Application no: **3/2021/0725**

Address: **Buck Inn Sawley Road Grindleton Lancashire BB7 4QS**

Proposal: **Proposed replacement two-storey side and single-storey extensions to rear, external and internal alterations including first floor conversion from manager's accommodation to four toilet ensuite bedrooms.**

The Local Highway Authority have viewed the plans and highway related documents and have the following comments to make:

6239 - P02 REV B

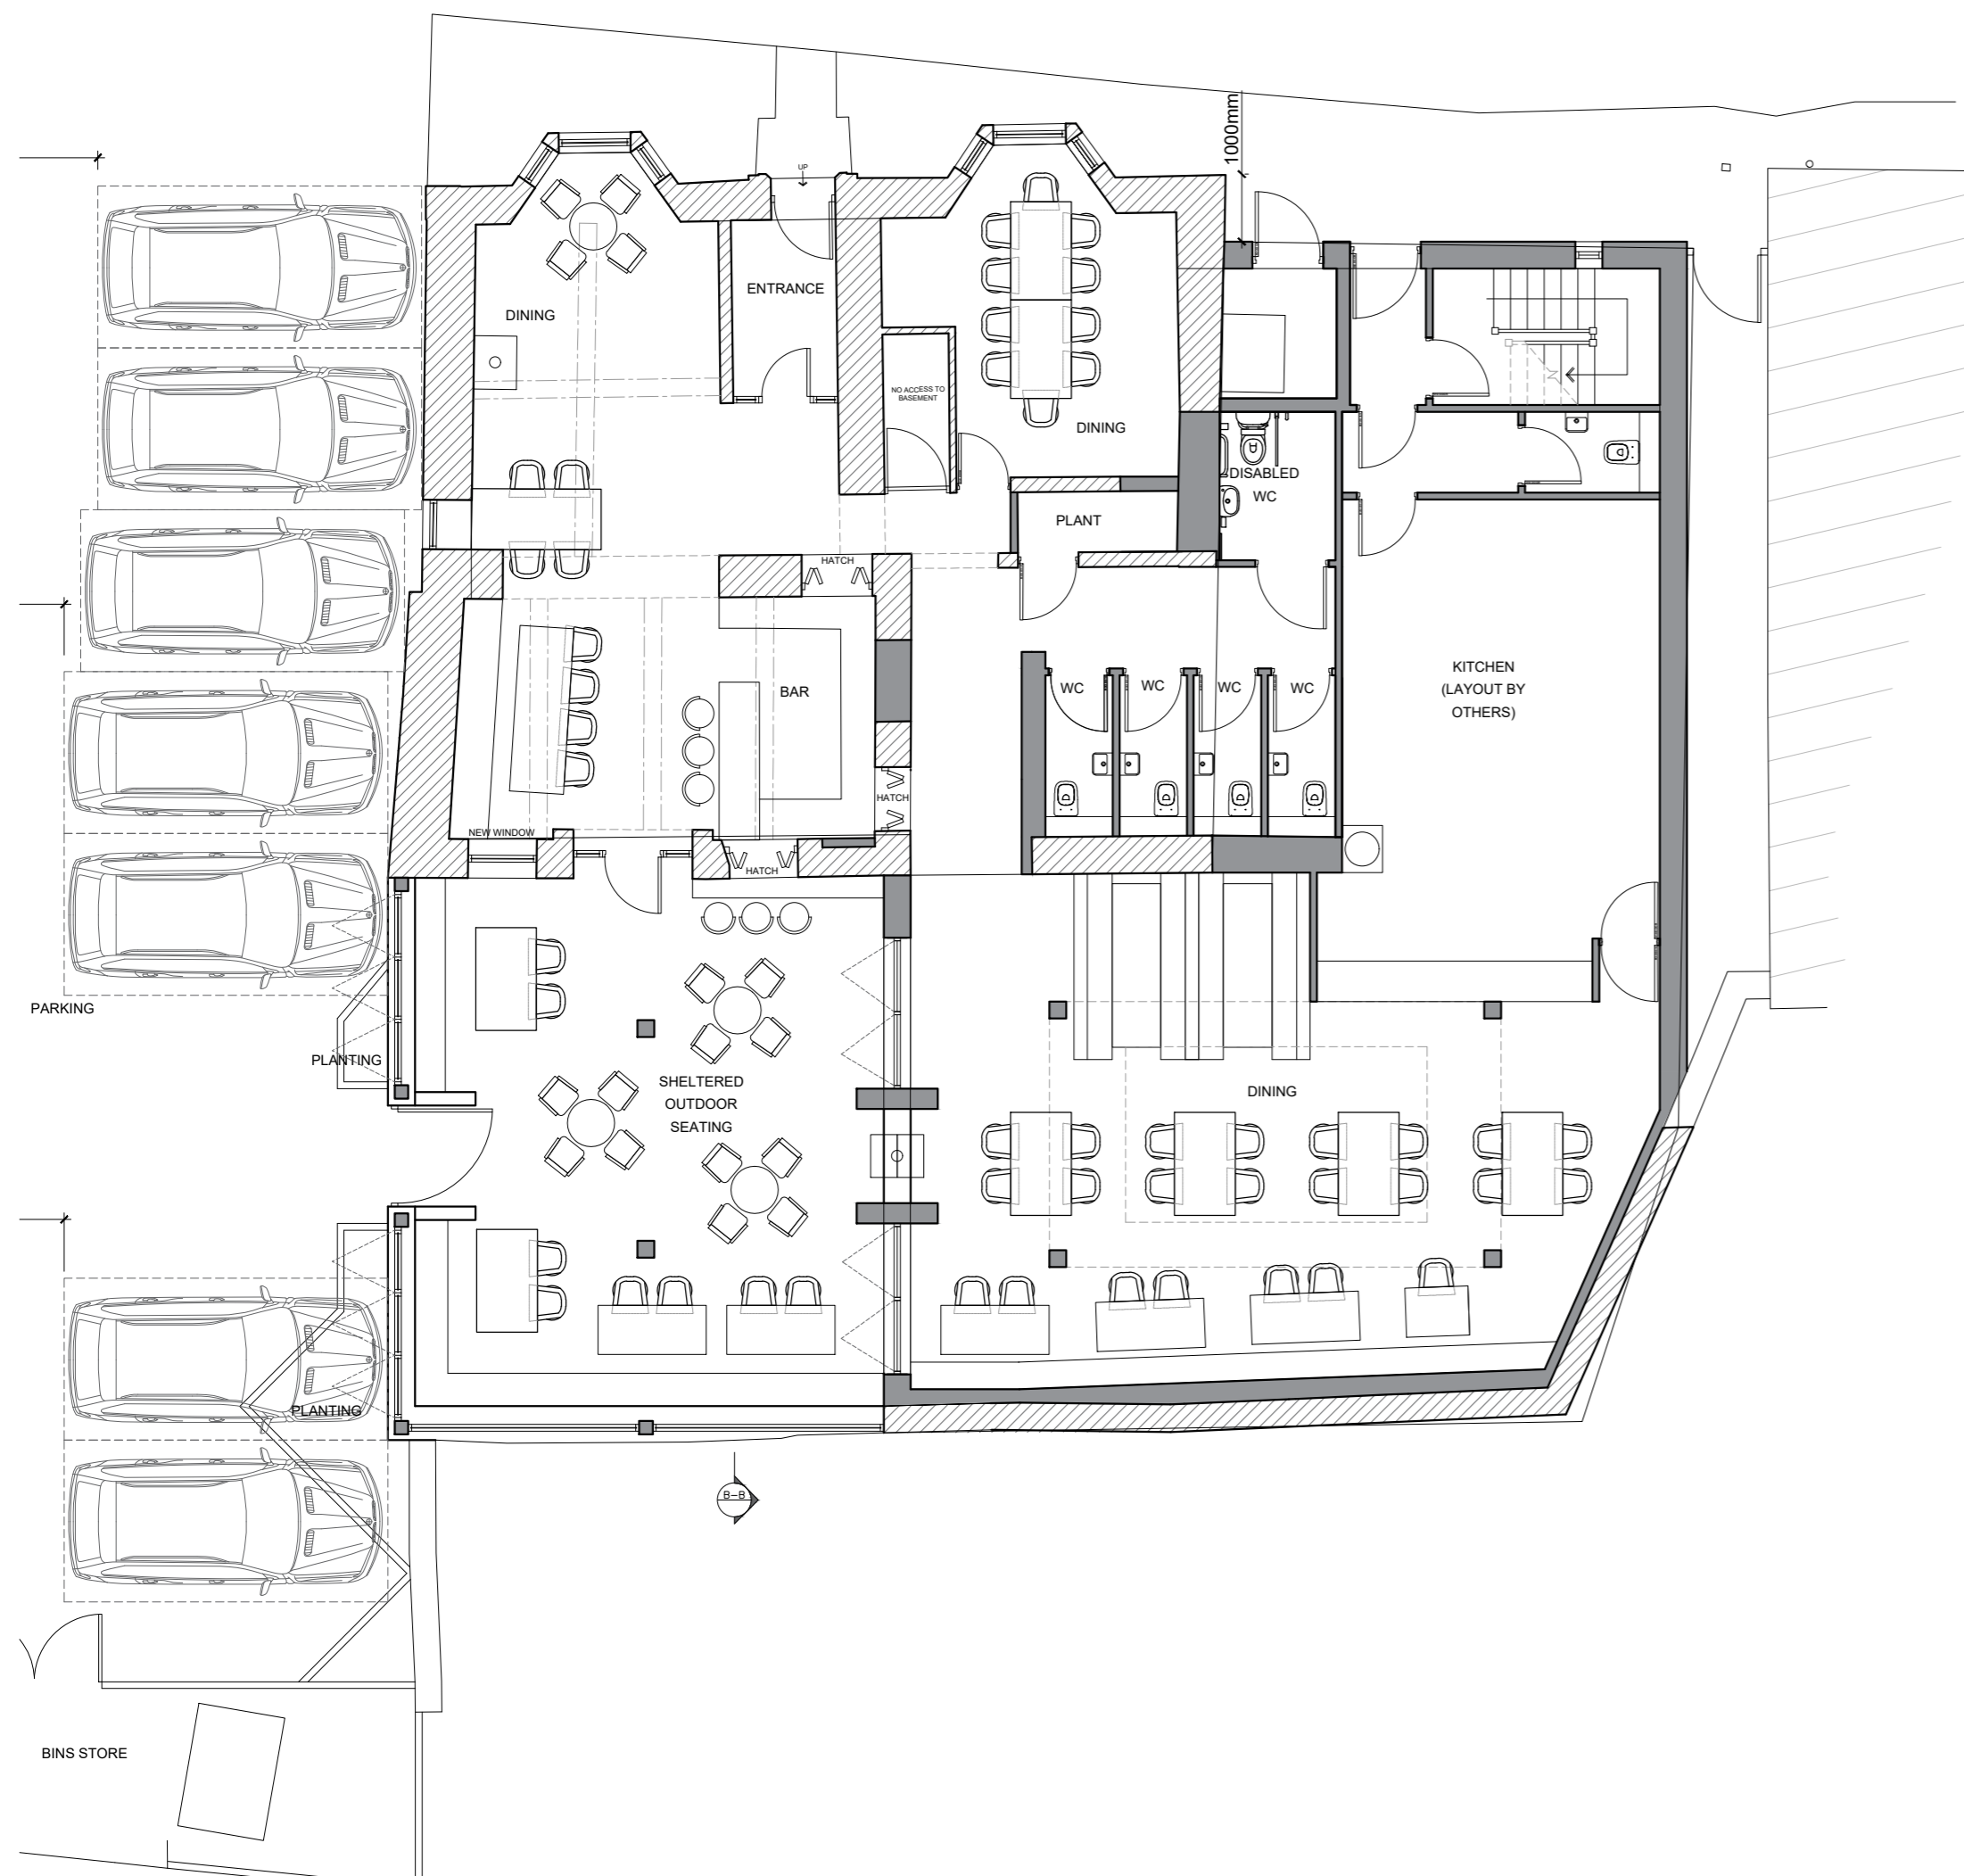
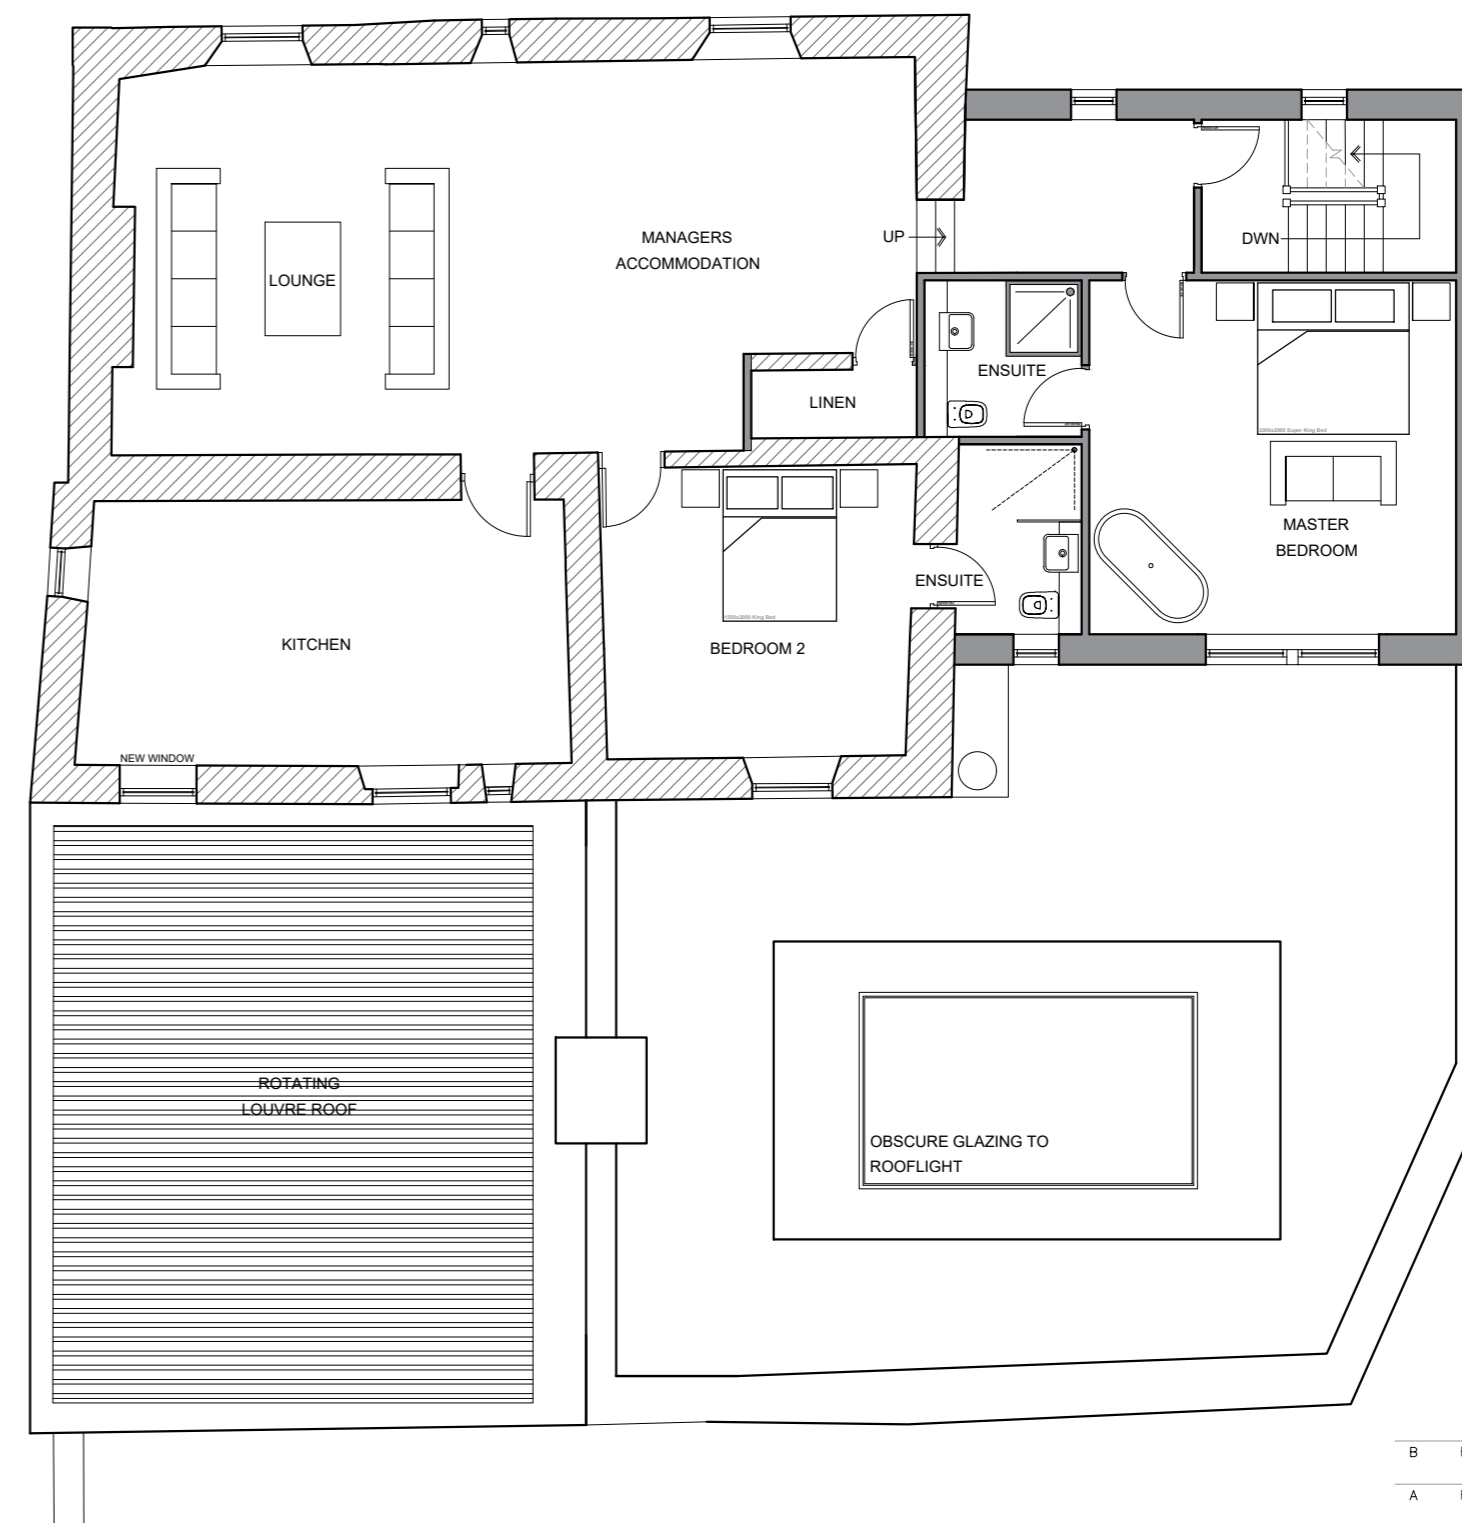
The first floor instead, as shown on SPA drawing number 6239-P03 Rev B titled "Proposed Floor Plans" will remain as existing as the landlords/managers flat.

**6239 - P01** REV B

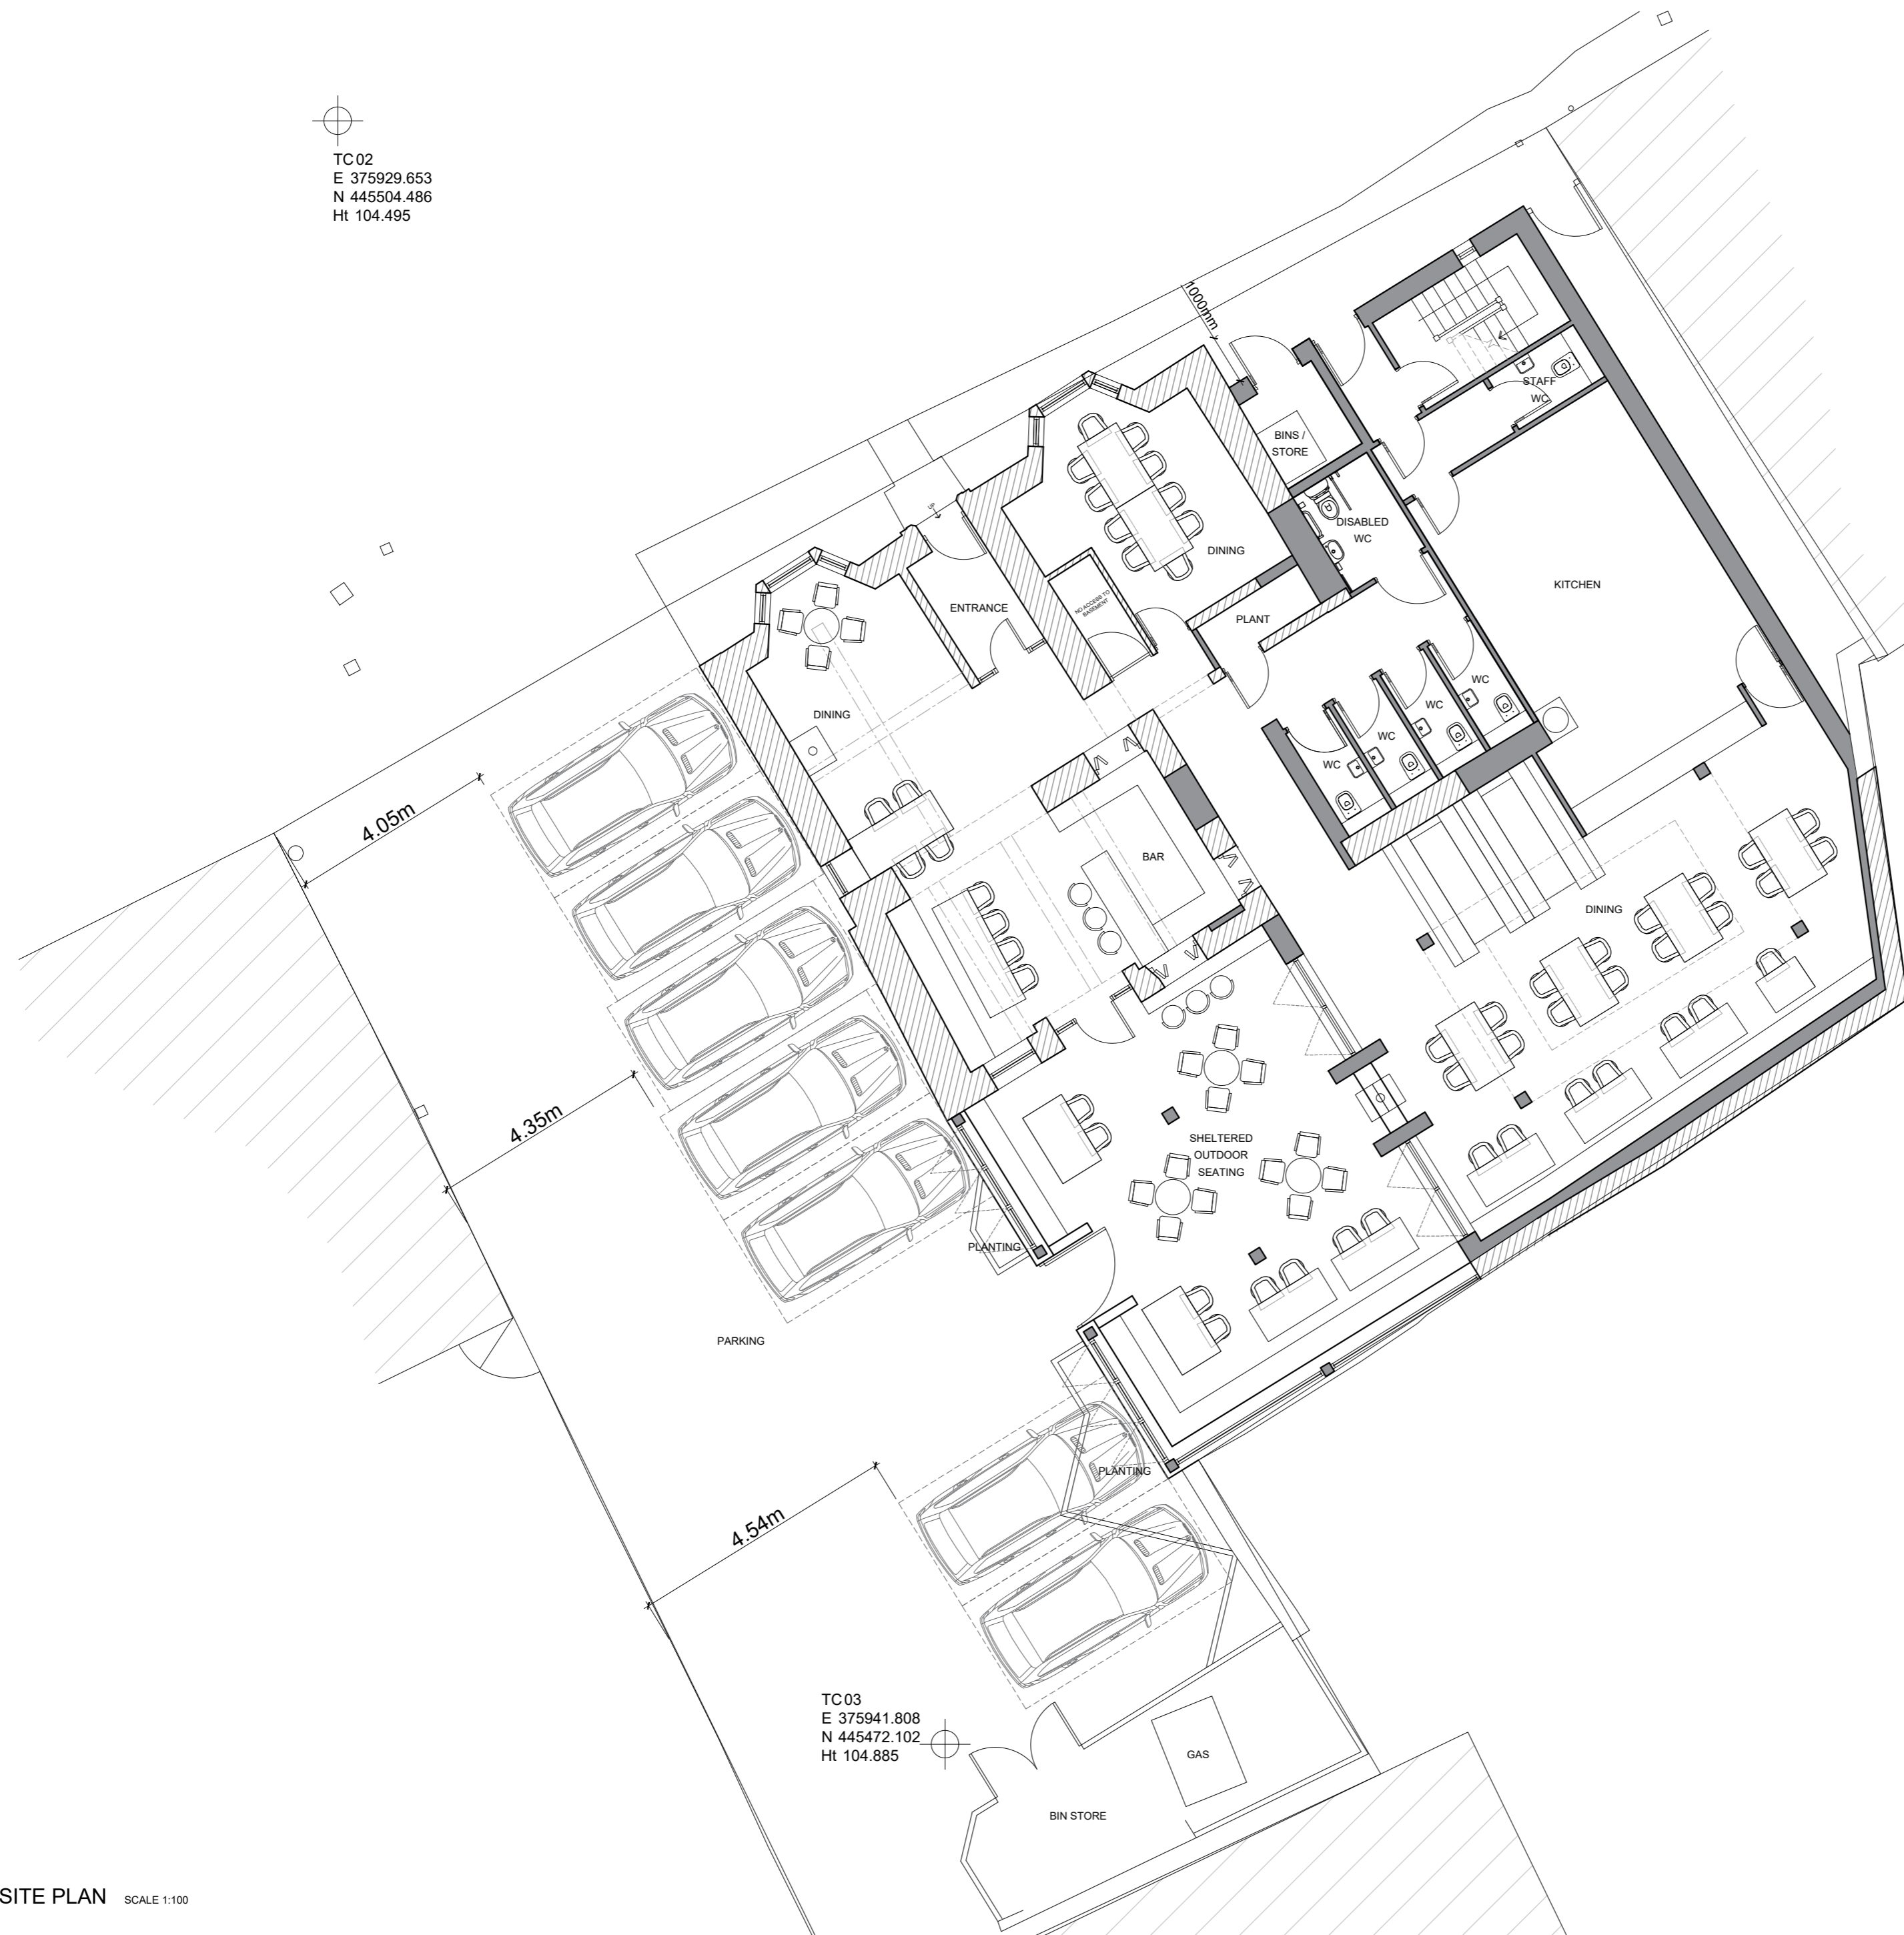
The LHA have reviewed SPA drawing number 6239-P01 Rev B titled "Proposed Site Plan" and understands that the site access will remain as existing. Therefore, with there being no change to the site access which has been established for a number of years and the site returning to its existing use as a Public House, the LHA have no objection to the use of the access.

However, the LHA have reviewed SPA drawing number 6239-P01 Rev B titled "Proposed Site Plan" and understands that the site can only provide 7 car parking spaces for the proposal. Therefore, the site has a shortfall in 24 car parking spaces.

Notwithstanding this the LHA will accept the shortfall in parking at the site. This is because the shortfall in parking is a pre-existing situation with 6 car parking spaces as stated on the Application Form being existing. Therefore, even without the proposed extension the site would have a considerable shortfall in parking and the Applicant would not require planning permission to make the site operational again. As a result of these reasons and the size of the extension being relatively marginal in terms of the size of the existing building, the LHA will accept the shortfall in parking.

1. No part of the development hereby permitted shall be occupied until such time as the access arrangements shown on SPA drawing number 6239-P01 Rev B have been implemented in full.

2. The development hereby permitted shall not be occupied until such time as the parking and turning facilities have been implemented in accordance with SPA drawing number 6239-P01 Rev B. Thereafter the onsite parking provision shall be so maintained in perpetuity.
